Application for a non-material amendment following a grant of planning permission.

Detached double garage. This application affects the character & appearance of the Aldwick Bay Conservation Area

Reference number: AW/308/15/HH

Change shape and scale of window above Garage door opening

PROPOSED ELEVATIONS (1/100)

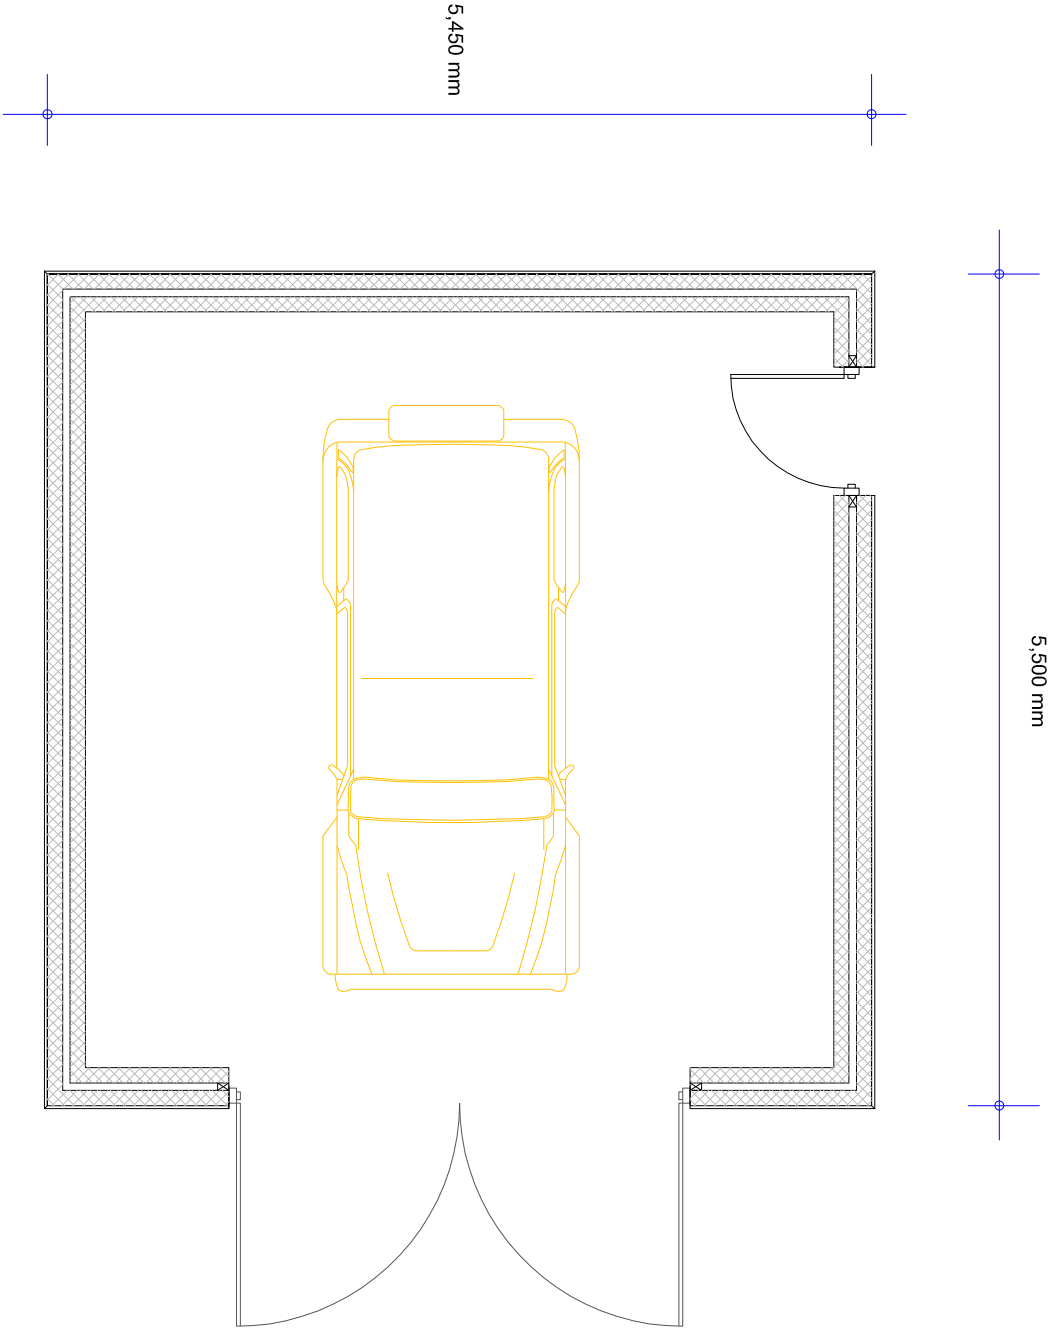
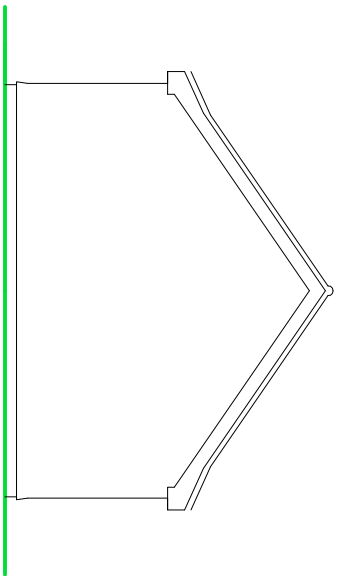
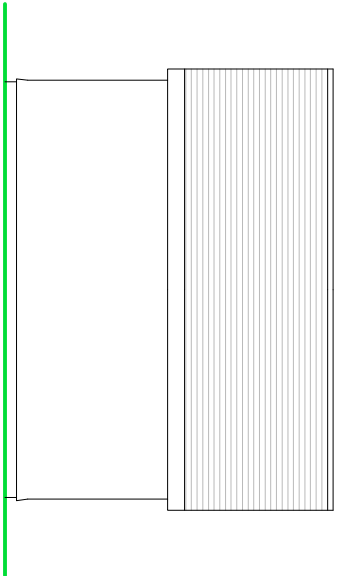
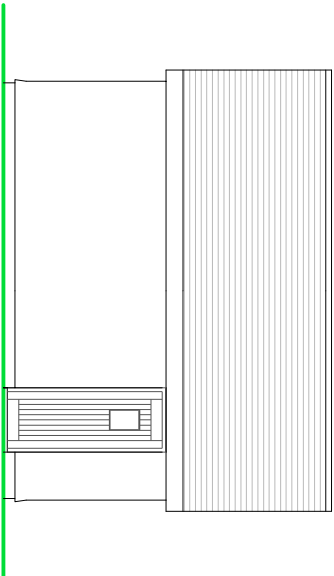
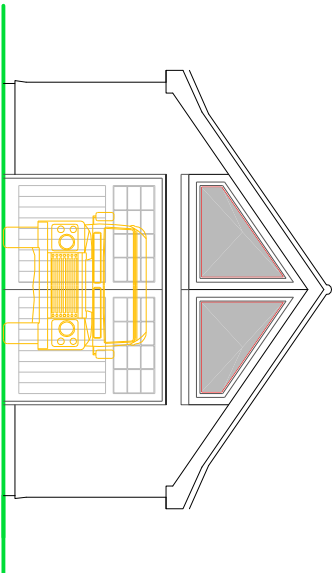
The original drawing was to show a window in the rough situation, whilst delaying the decision on nearing completion. The new widow will allow more natural light into the garage.
